46 50 SAWYER STREET

May 27, 1981

Re: 48 Sawyer Street

Your permit application to change the use from three to four families, as per plans, at the above named address, is hereby approved subject to the following conditions:

Proposed 4<sup>th</sup> Apartment  
Third Floor

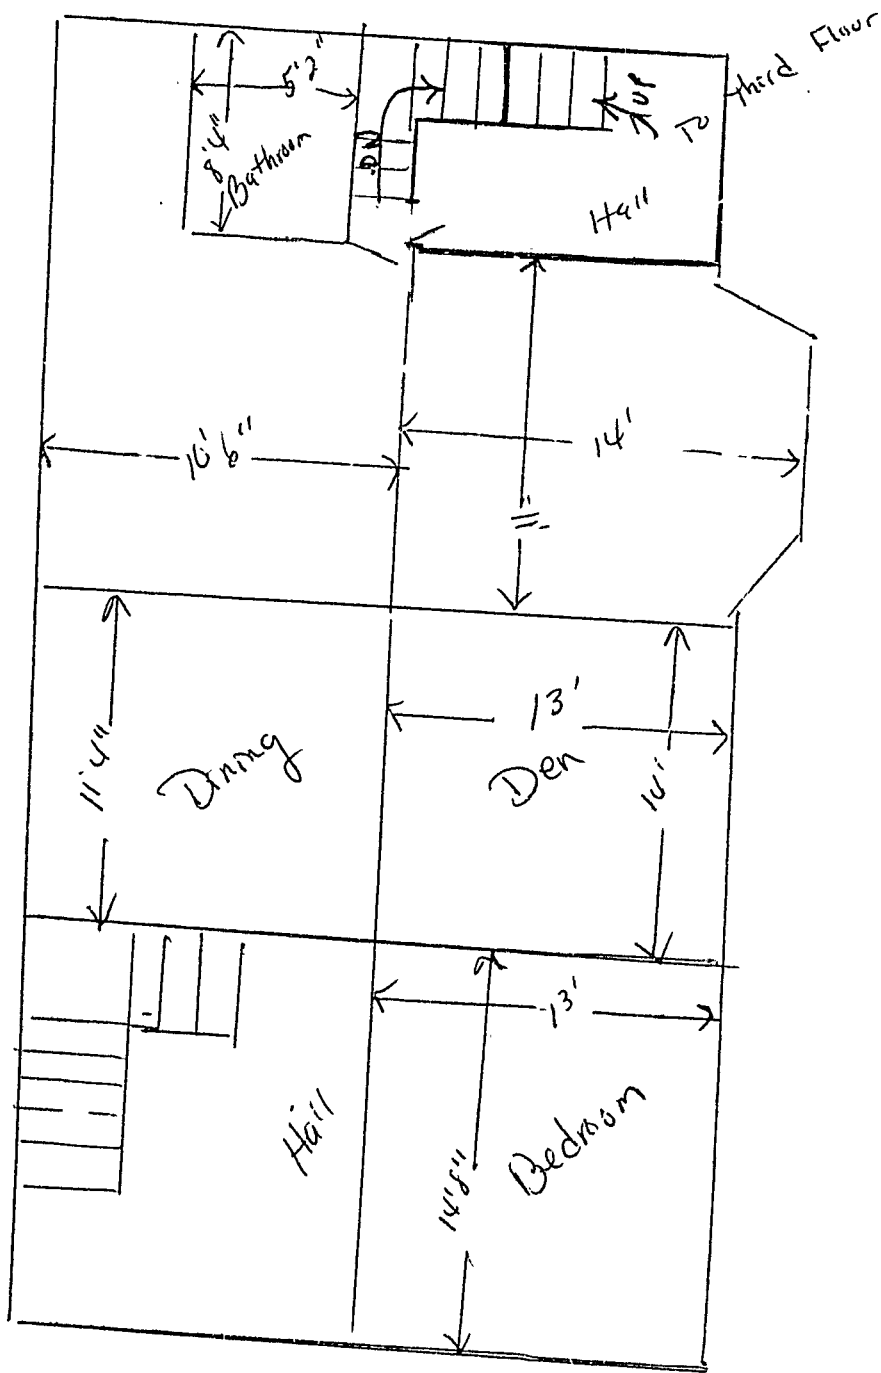
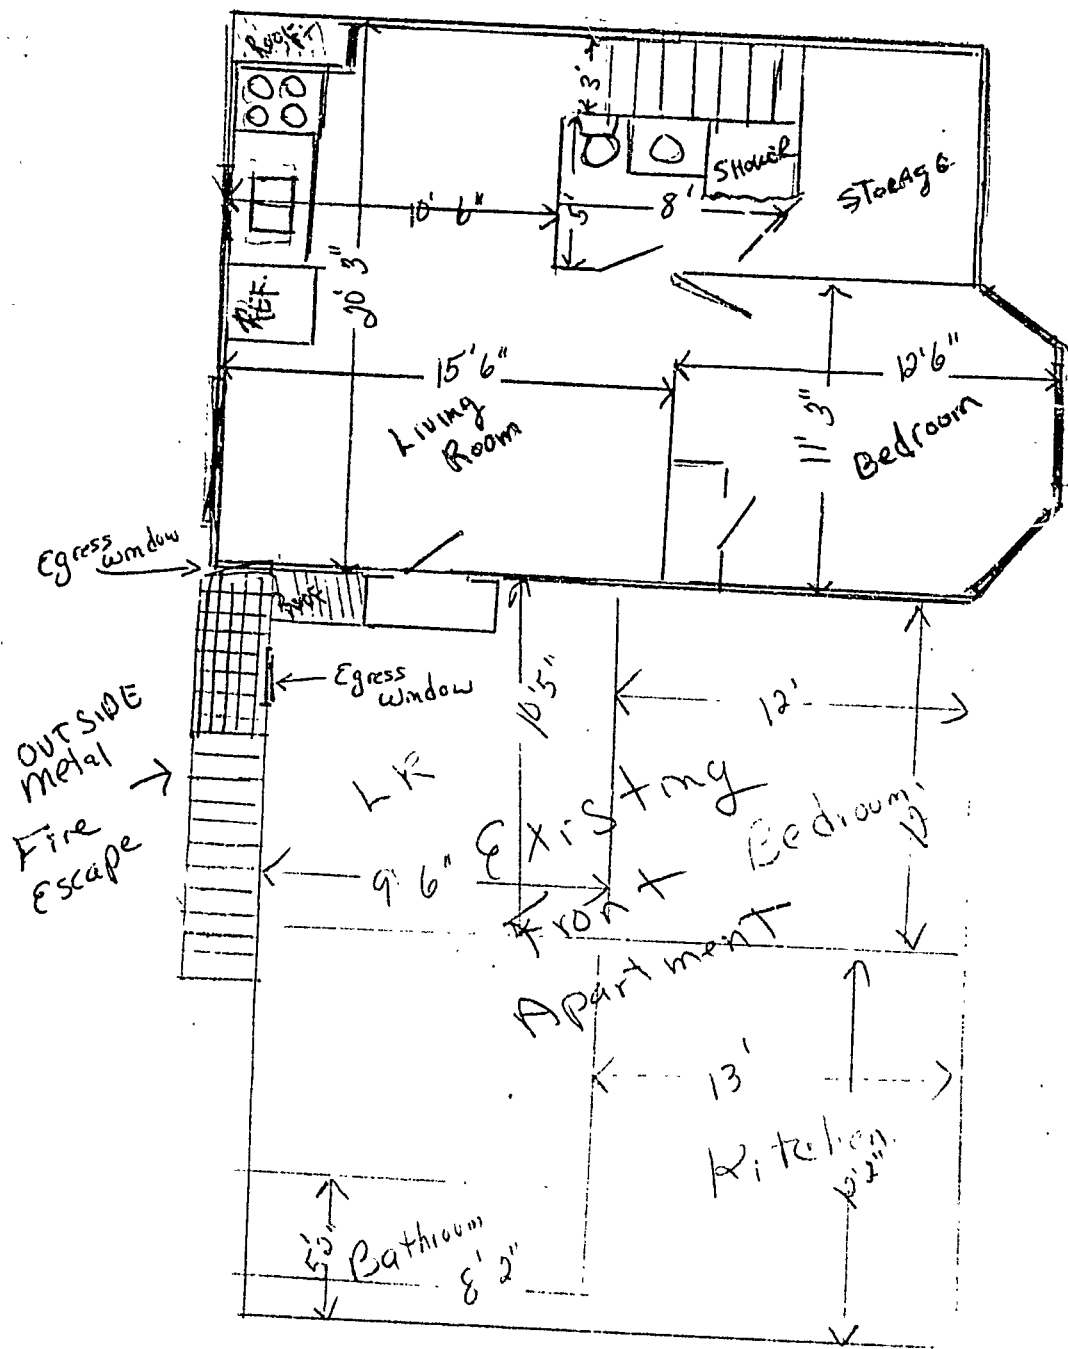
14. All vertical openings (stairways) shall be enclosed with construction having a fire rating of at least one hour including fire door with self closers.

18. Each apartment shall have access to two separate and remote approved exits. Upon entering the exit enclosures one shall be able to remain in the protected enclosure until reaching the building exterior.
